Portishead Branch Line (MetroWest Phase 1)

9.9.2 ExA.LIR.D2.V1 – Applicant's response to the North Somerset District Council Local Impact Report

Date: November 2020

Drawing
PORTISHEAD STATION CAR PARK
LAYOUT, LANDSCAPING AND NEW
BOULEVARD AND ACCESS PLAN
SHEET 2 OF 3

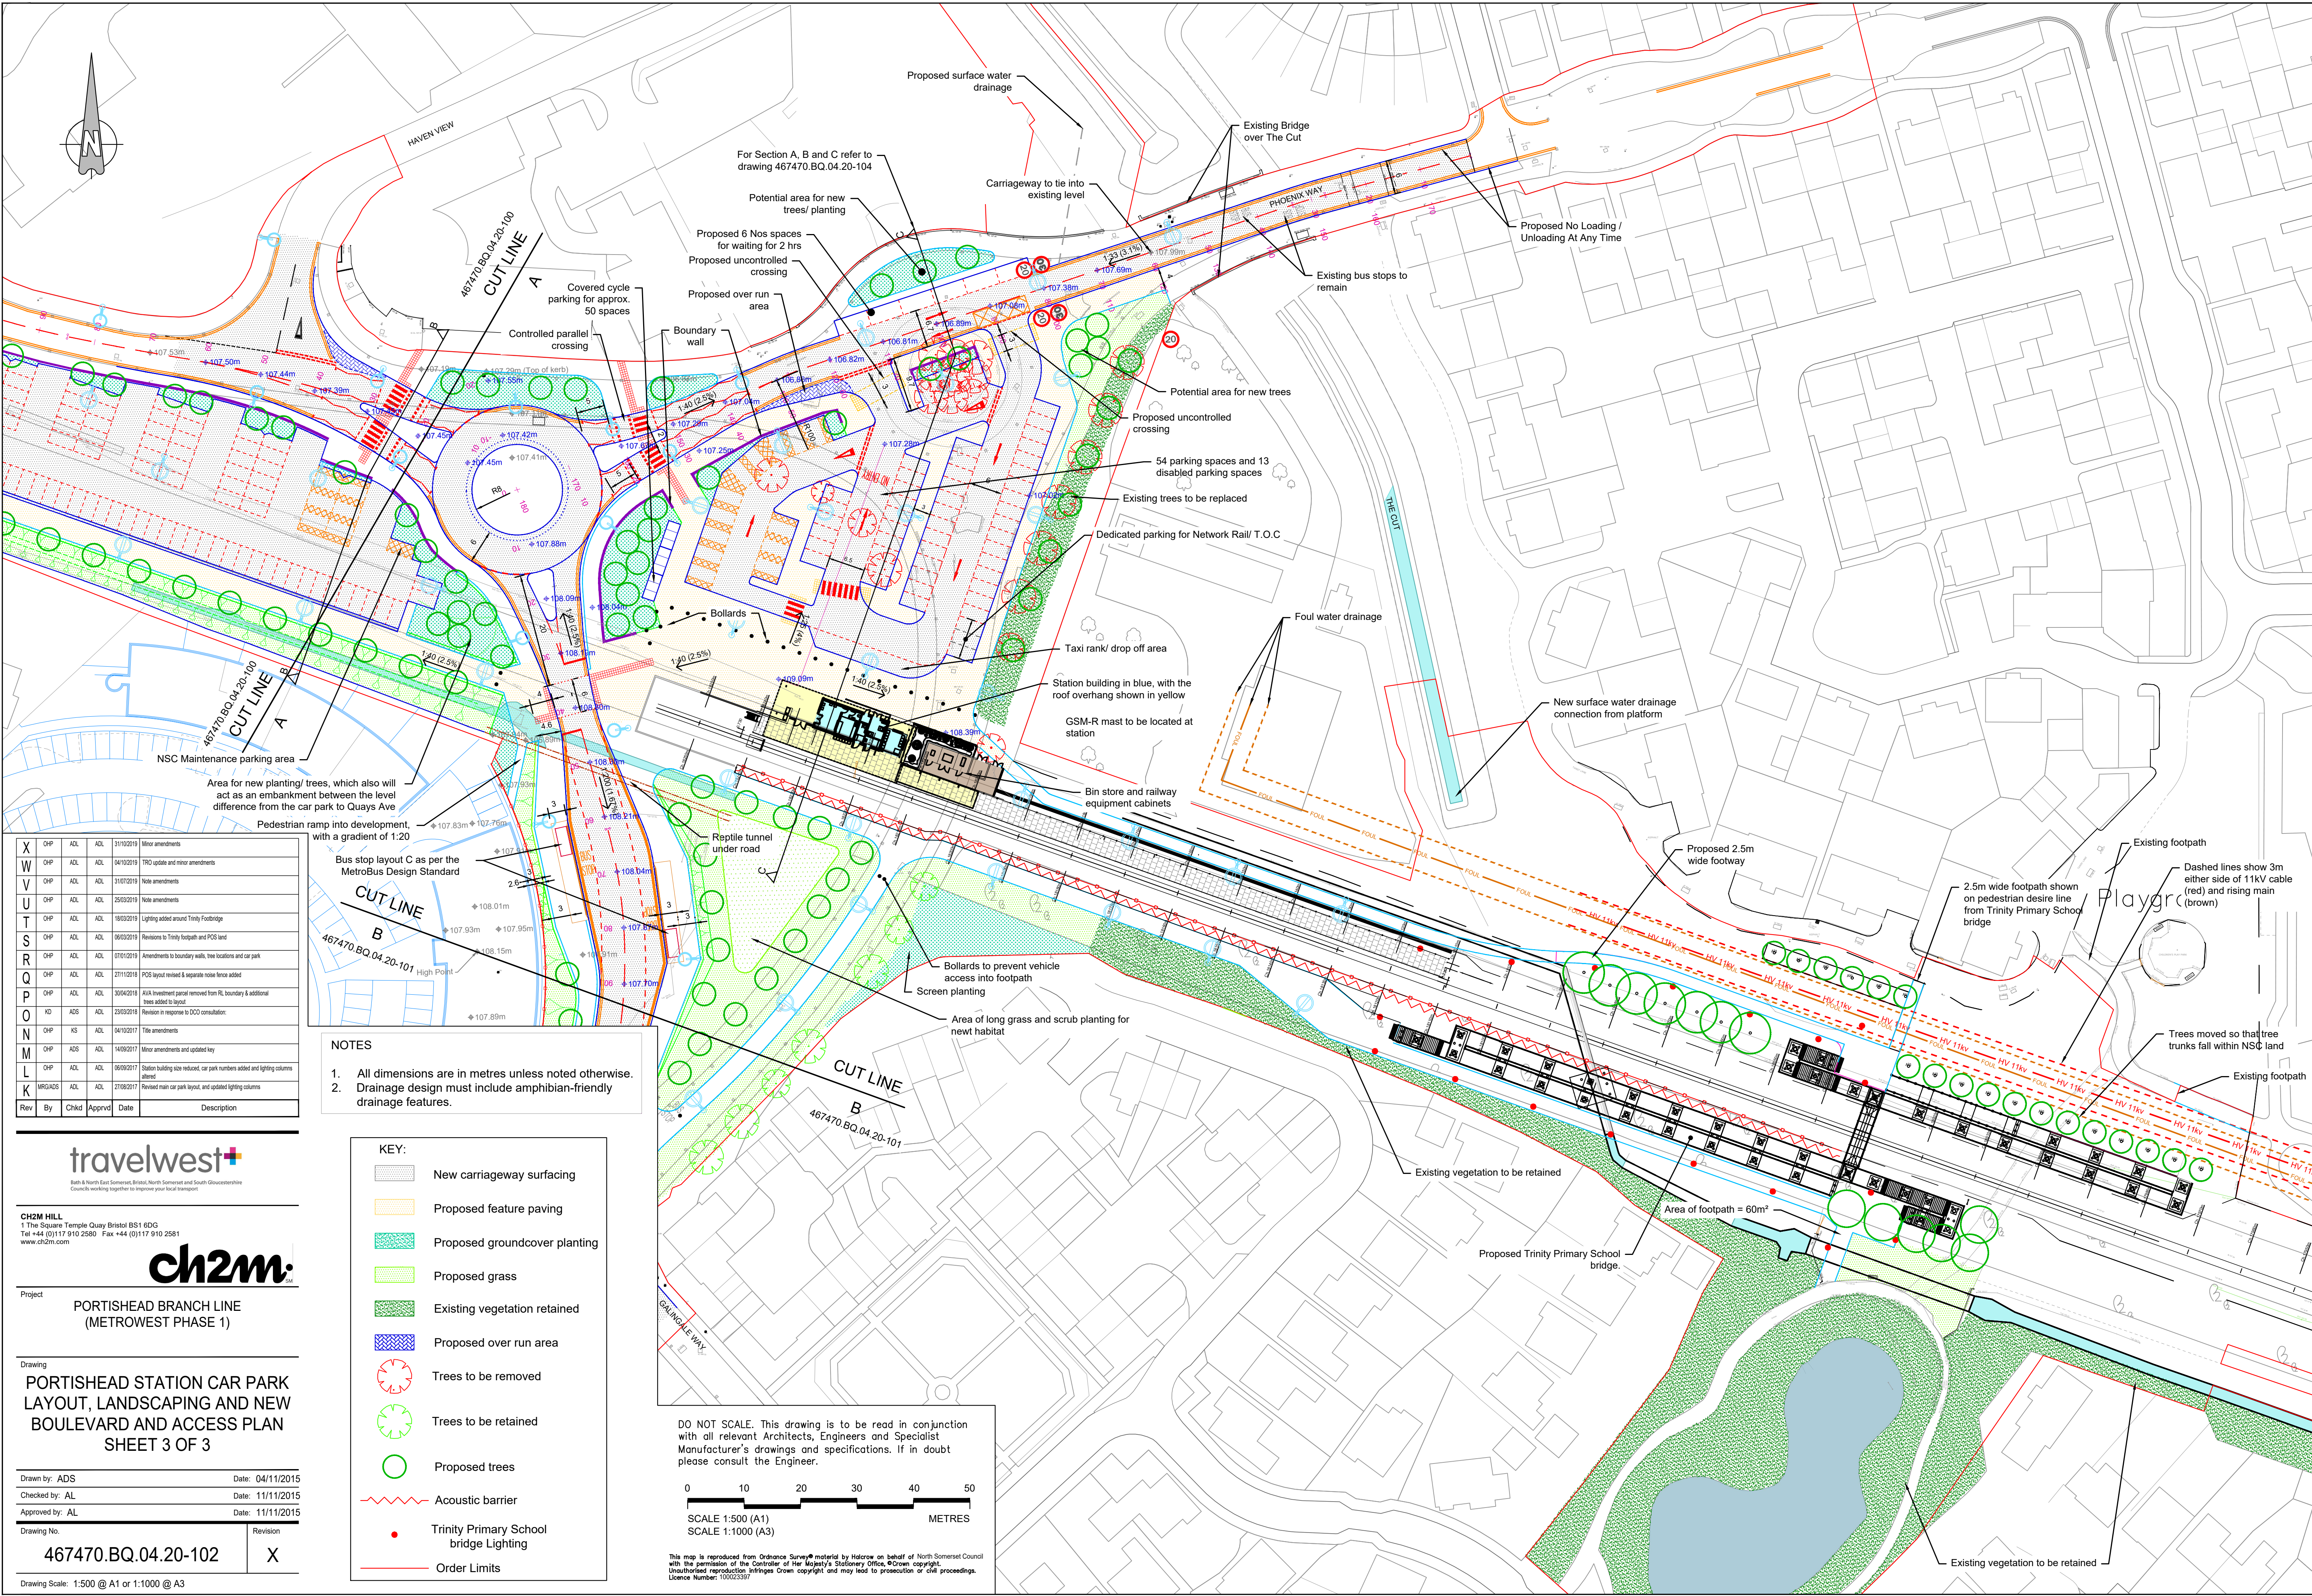
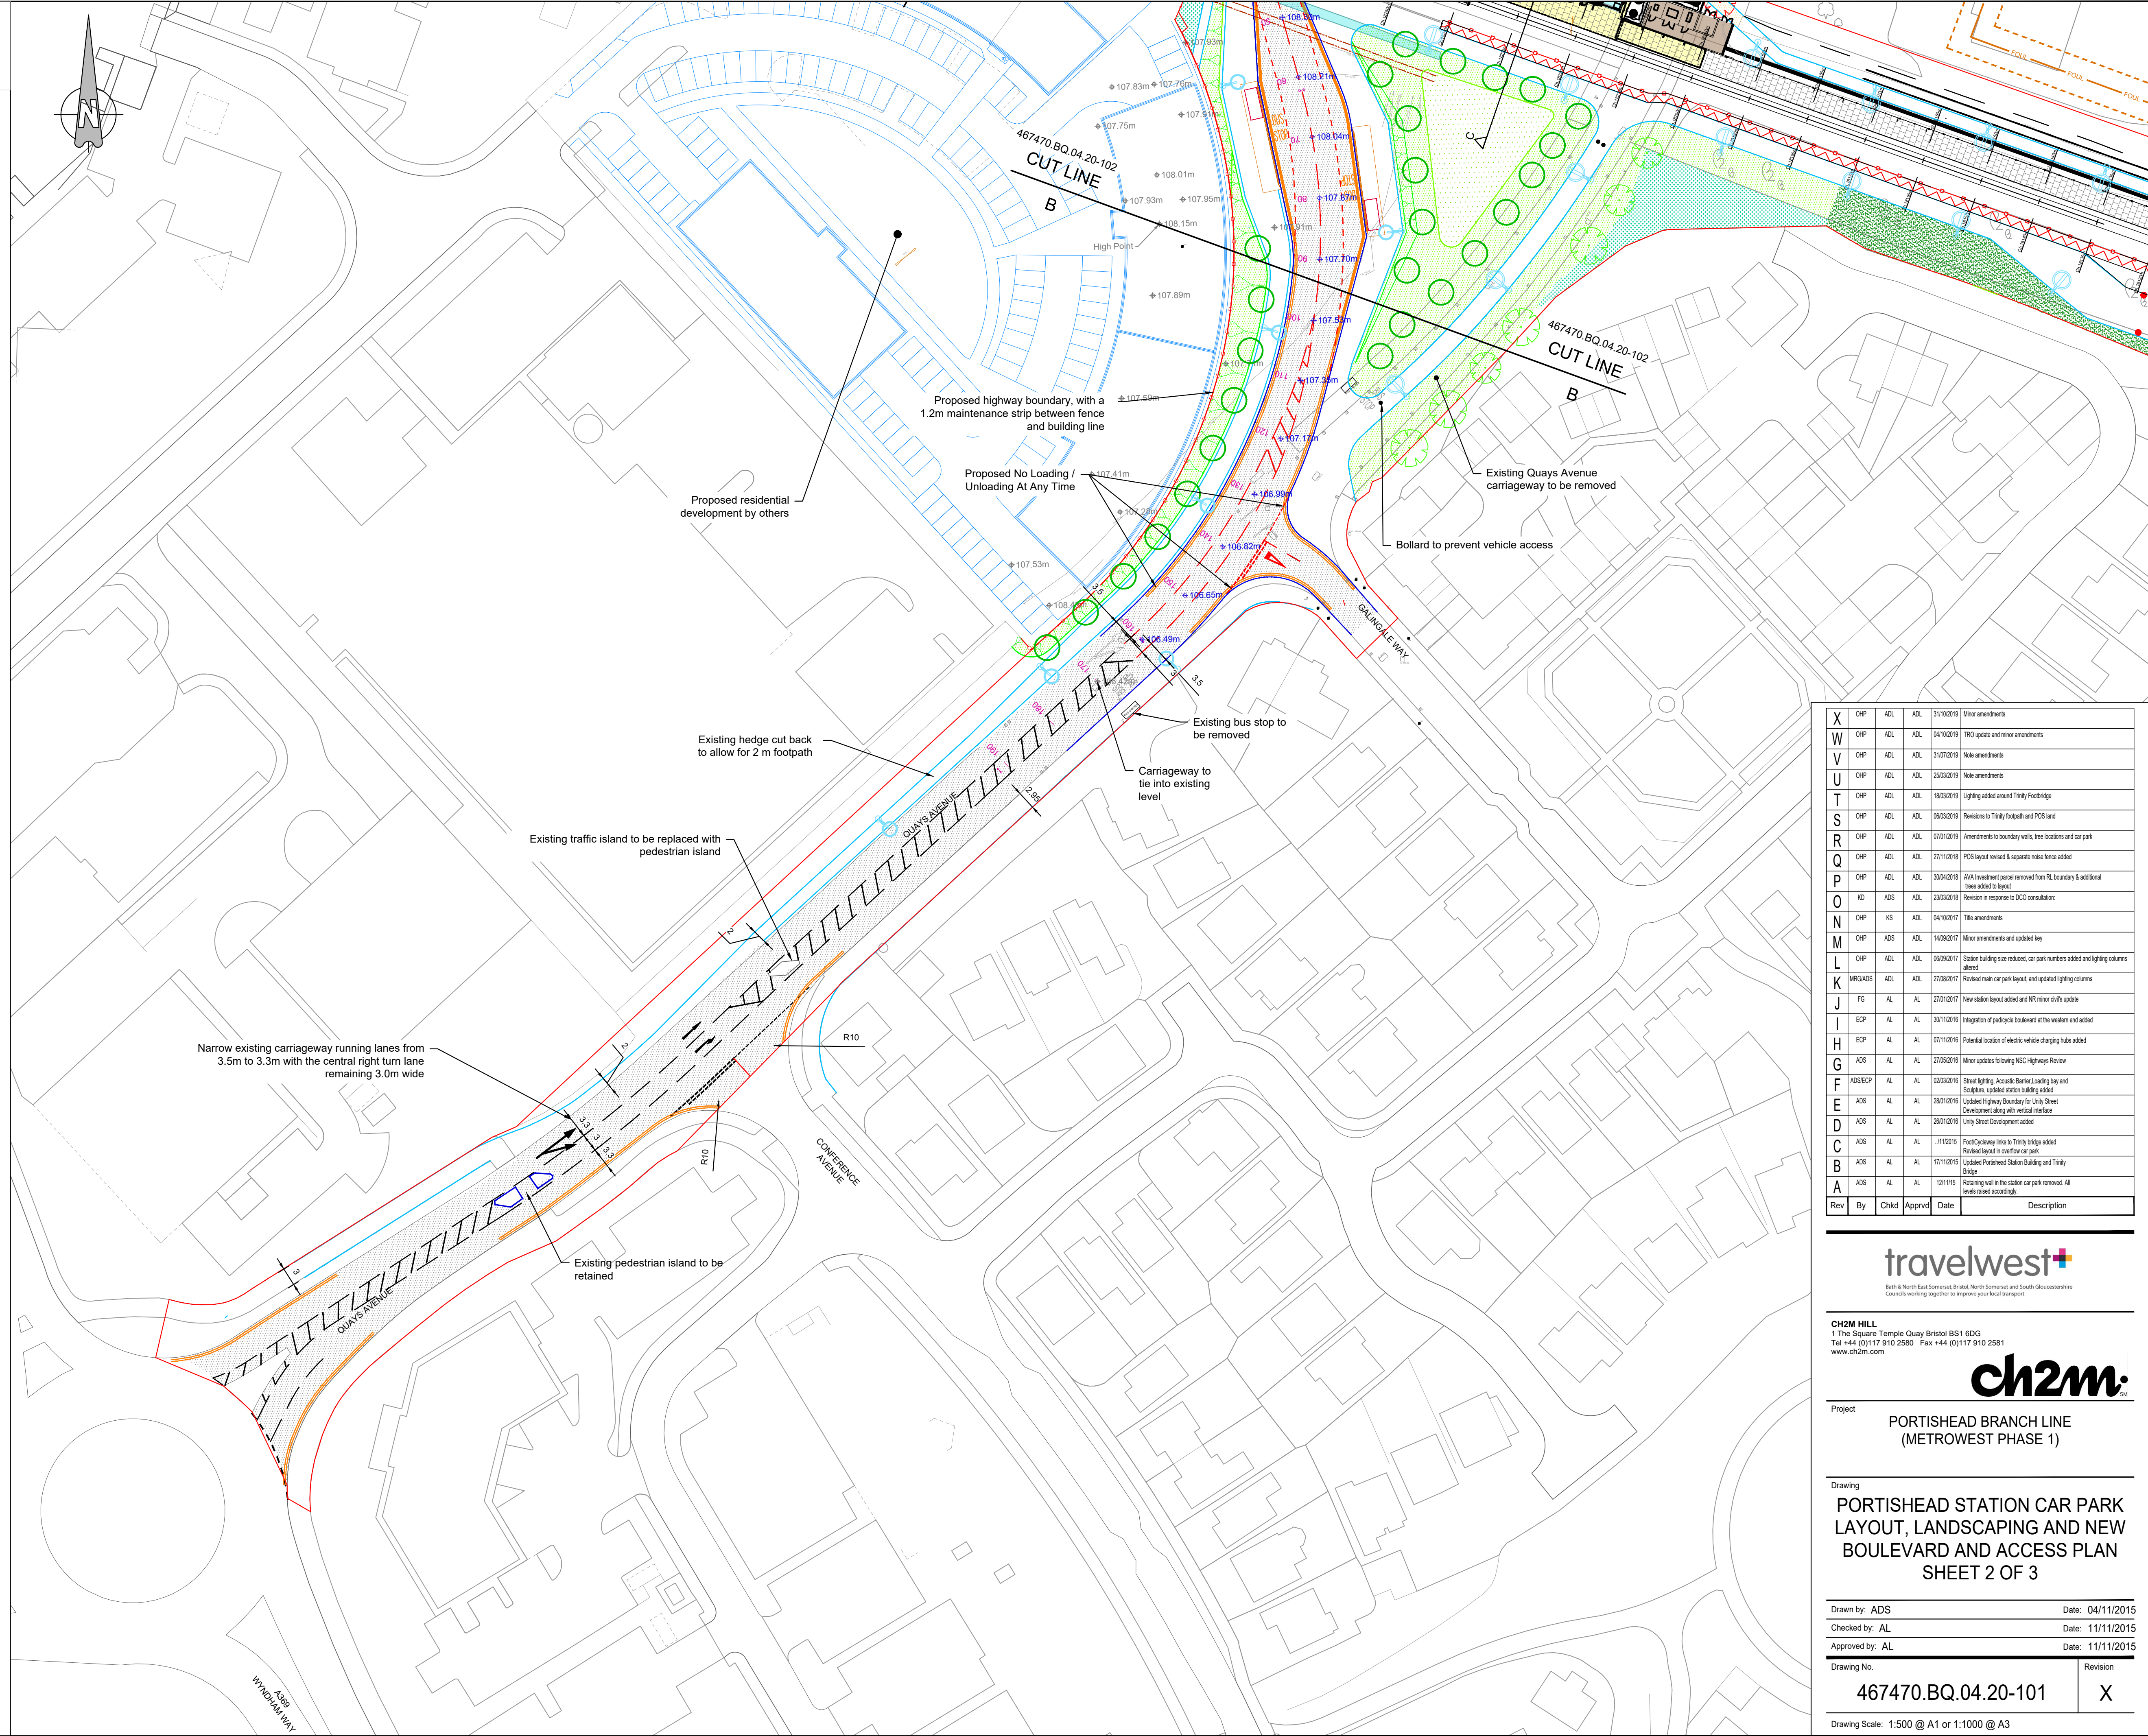
18. The proposed Portishead station is well located and is planned to be accessible by varied means of travel. It is considered to be a functional design that is unlikely to be out of character with its largely modern surroundings. The Council considers that this is an important location and looks forward to further discussion over the detailed design and that of the track end wall, to give it presence as

an important community asset and how it can be future proofed to adapt to changing needs. It is considered that during the construction period there will be 19. adverse impacts on nearby residential uses. Some acoustic protection will be required before operational use commences. There are likely to be adverse impacts on outlook for some dwellings from the footbridge at Portishead, though these will be mitigated as far as possible given the restricted space available. It is considered that mitigation measures will assist to some degree on minimising overlooking and potential overbearing effects, though it is clear that the bridge in particular is a substantial structure. 20. In respect of Pill station there is likely to be considerable disruption for some residents during the construction period and a need to ensure discussion over detailed design, pedestrian access to the station and matter such as bat roost protection and lighting and landscaping. In the restricted roads there will be a need to look closely at the drainage design, and traffic management during the construction period. TRAFFIC AND TRANSPORT Noted. 21. There will be some permanent changes as a result of the proposals. The Applicant refers to the draft SoCG with the Council (9.3.1 ExA.SoCG-The DCO involves realignment of Quays Avenue which will be a NSC.D1.V1/ REP1-016). Where any issues remain to be agreed upon, the significant change to the road network close to the heart of Applicant will work with the Council to finalise any outstanding points in the Portishead. Due to the scale of the undertakings there will be SoCG. considerable temporary changes to the network that must be carefully managed to avoid impacts on travel, the environment, local residents and businesses. This will, in some locations, such as Pill, require substantial change or modernisation to local infrastructure such as drainage. **PUBLIC RIGHTS OF WAY** Noted. 22. The mitigation proposals are generally satisfactory here there are The Applicant refers to the draft SoCG with the Council (9.3.1 ExA.SoCGimpacts on the network though there are some specific locations NSC.D1.V1/ REP1-016). Where any issues remain to be agreed upon, the Applicant will work with the Council to finalise any outstanding points in the where there are remaining concerns. SoCG.

The Applicant refers to the SoCG with the Council (9.3.1 ExA.SoCG-NSC.D1.V1/ REP1-016). Where any issues remain to be agreed upon, the Applicant will work with the Council to finalise any outstanding points in the SoCG.
